# City of Albuquerque

RE: DRAINAGE PLAN FOR THE FOURTH STREET FUELING FACILITY  
(J-14/D98) & 4309.90 ENGINEER'S STAMP DATED MARCH 6, 1992

Based on the information provided on your submittal of March 9, 1992, the following concerns must be addressed prior to final approval.

CITY OF ALBUQUERQUE PUBLIC WORKS DEPARTMENT ENGINEERING GROUP					
TITLE: FOURTH STREET FUELING FACILITY DRAINAGE PLAN					
APPROVALS	ENGINEER	DATE	APPROVALS	ENGINEER	DATE
D.R.C. Choir					
Trans. Dev.					
Utility Dev.					
DRAWING NO.	4309.90	MAP NO.	H14,J14	SHEET	OF

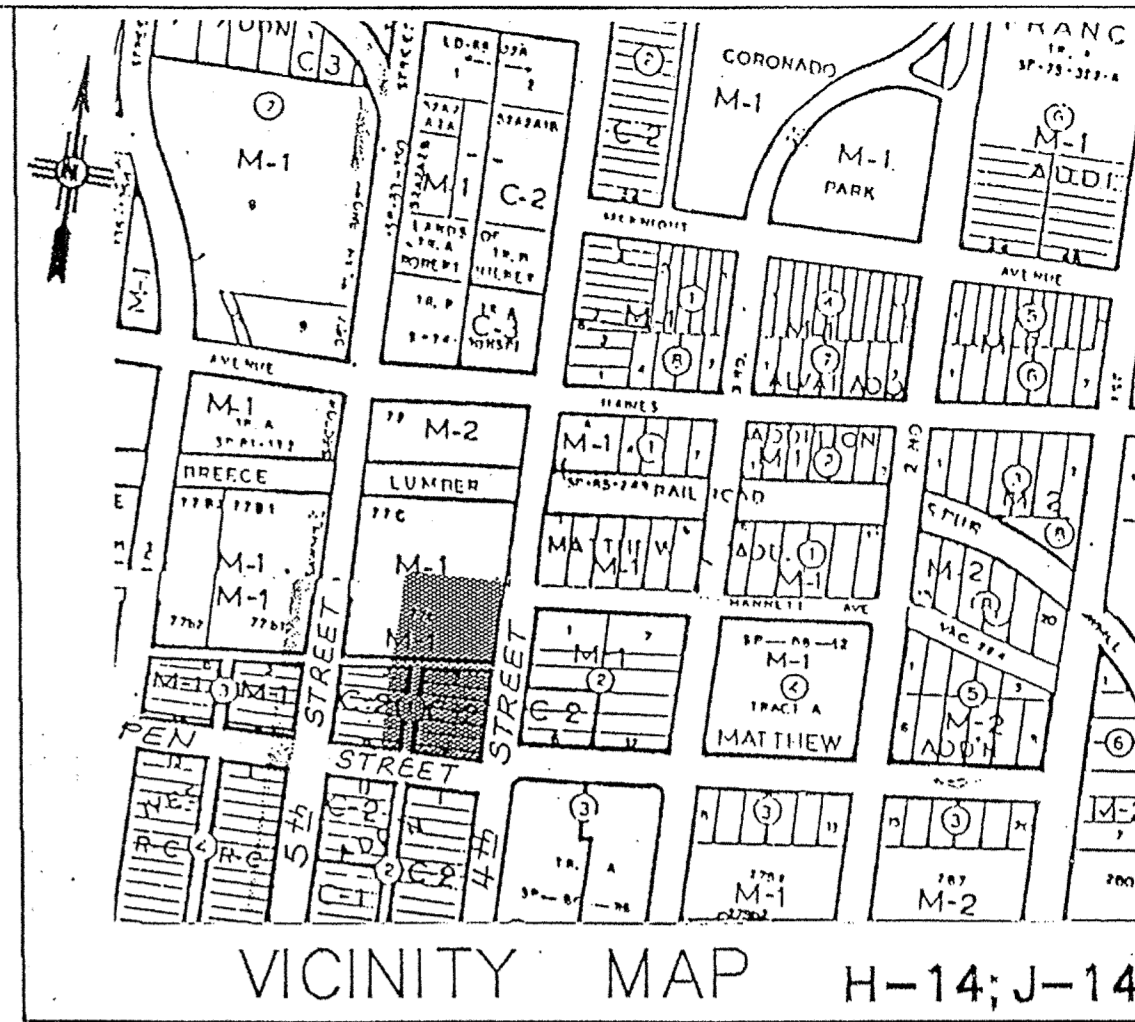
- ✓ 1. Bench Marks - location, description and elevation
  - a. Albuquerque Control Survey Vertical Datum used. - "Z-H14"
  - b. Temporary bench mark on site permanently marked. R.R. SPIKE in P.P.
- ✓ 2. Site Description
  - ✓ a. Vicinity map, please include the zone atlas map index number. H14 ; J14
  - ⓑ Legal description or current plat. - "see Attached"
3. Flow volumes and rates - calculations showing on-site undeveloped and developed flow volumes and rates. Use attached emergency rule criteria for your calculations. - *Shown on Plan*
4. Are there any off-site flows entering from the surrounding properties? *No*
- Ⓢ New or proposed elevations must be determined and not estimated.  
*"As per telephone conversation"*

6. Please include the as-built information on the existing catch basin and the invert at the outlet of the sidewalk culvert. *Not Available As per telephone conversation.*
7. Engineer's Certification per the DPM Engineer's Certification Checklist will be required prior to Certificate of Occupancy release.
